# **GRAVENEY with GOODNESTONE PARISH COUNCIL**

Application by Cleve Hill Solar Park Limited for an Order Granting Development Consent for the Cleve Hill Solar Park Project

Graveney with Goodnestone Parish Council is presenting this written submission to reinforce and expand on the points raised in the oral submission which was made at the hearing on 11<sup>th</sup> September, specifically in relation to Traffic and Transport.

Construction Traffic Routing
Figure 14.1

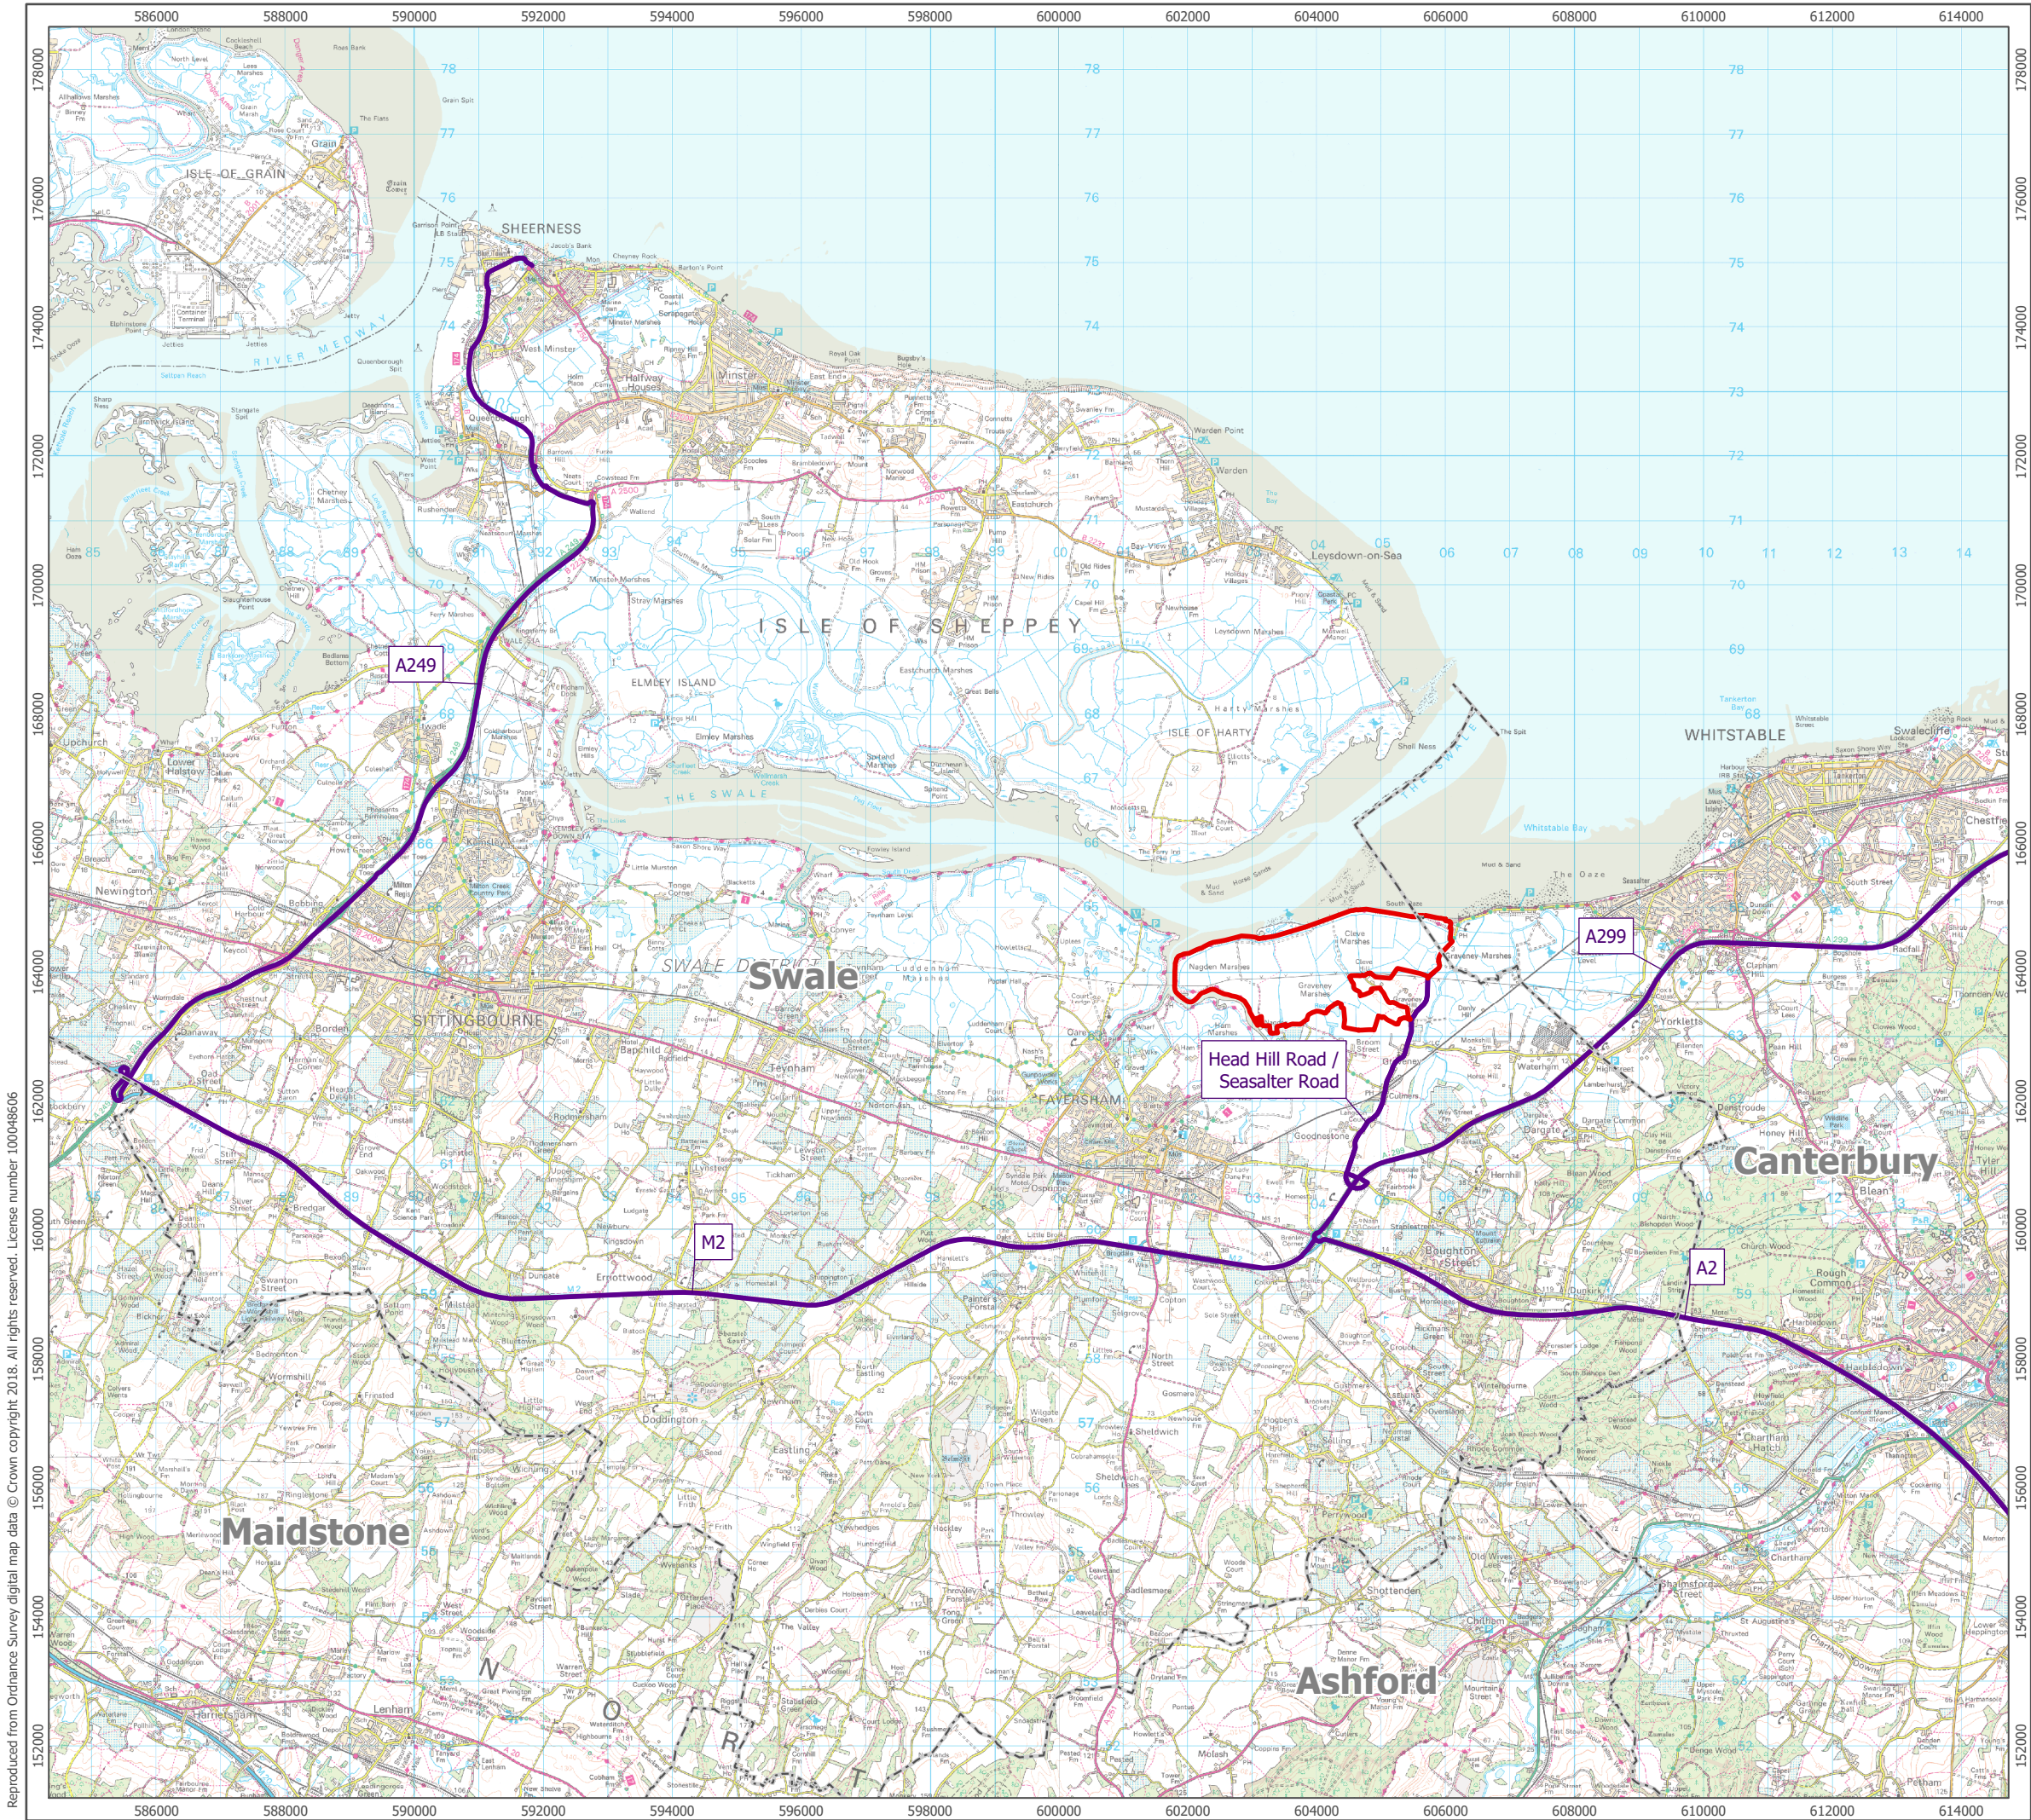
6. In 4.2 based on our long standing experience of existing vehicle movements along the designated route of Seasalter Road and Head Hill Road we would submit that there are other locations where a large HGV or even an LGV and a large car may experience difficulties in (a) passing or (b) experience restrictions on forward visibility, contrary to 4.2.3. Those additional locations falling into category (a) would be along the line of the conifer hedge by Barons and Hobbits Oasts and the section of the road between Goodnestone Lane and the approach to Langdon Manor Farm. We also consider that the entire length of Head Hill Road from The Lodge to the top of the road should be included, contrary to 4.2.6. Those locations falling into category (b) would be Graveney Railway Bridge, Goodnestone Lane bend and Poplar Hall bend. In particular, we would mention the Sandbanks Lane junction at Graveney Railway Bridge where visibility for cars turning left or right from Sandbanks Lane is very restricted and with the significant increase in construction vehicle movements, special measures for this location would need to be put in place.

7. In view of the number of width and visibility limitations associated with the designated route we note that the applicants do not see the need to propose any passing places; we would submit that this would be a vital and effective mitigation measure against the inevitable grid lock on the roads serving the villages. One cannot rely upon the long term use of private land, such as driveways and forecourts, to assist, as these cannot be guaranteed as is evident along Waterham Lane where owners have taken measures to close passing places on their land.

8. No account has been taken in the methodology or analysis as to the effect of seasonal growth of the roadside hedgerows along the designated route as this can serve to further restrict the clearance for passing vehicles.

9. No account has been taken of cautious or hesitant drivers using the designated route; one cannot assume that plan measurements correspond with the reality of a large HGV or LGV being able to pass another vehicle and tolerances need to be reflected in the calculations to take account of realistic clearances from roadside hedgerows and banks , and between passing vehicles.

10. No account has been taken of multiple vehicles using the designated route at the same time which would potentially be contrary to 4.2.3 as other vehicles could easily create a queue in the event of a hold up thus exacerbating any congestion.

11. Hold ups could easily develop on account of parked cars, farm traffic, pedestrians or cyclists and we would stress that as the designated route is part of a National Cycle Route (NCR) we often have lines of cyclists travelling through the villages which slows the traffic flow even more. The applicants identified the NCR as a sensitive receptor in their Preliminary Environmental Information Report and we consider that the safety of cyclists should be of paramount importance and their presence is in direct conflict with the expected construction traffic movements through the villages.
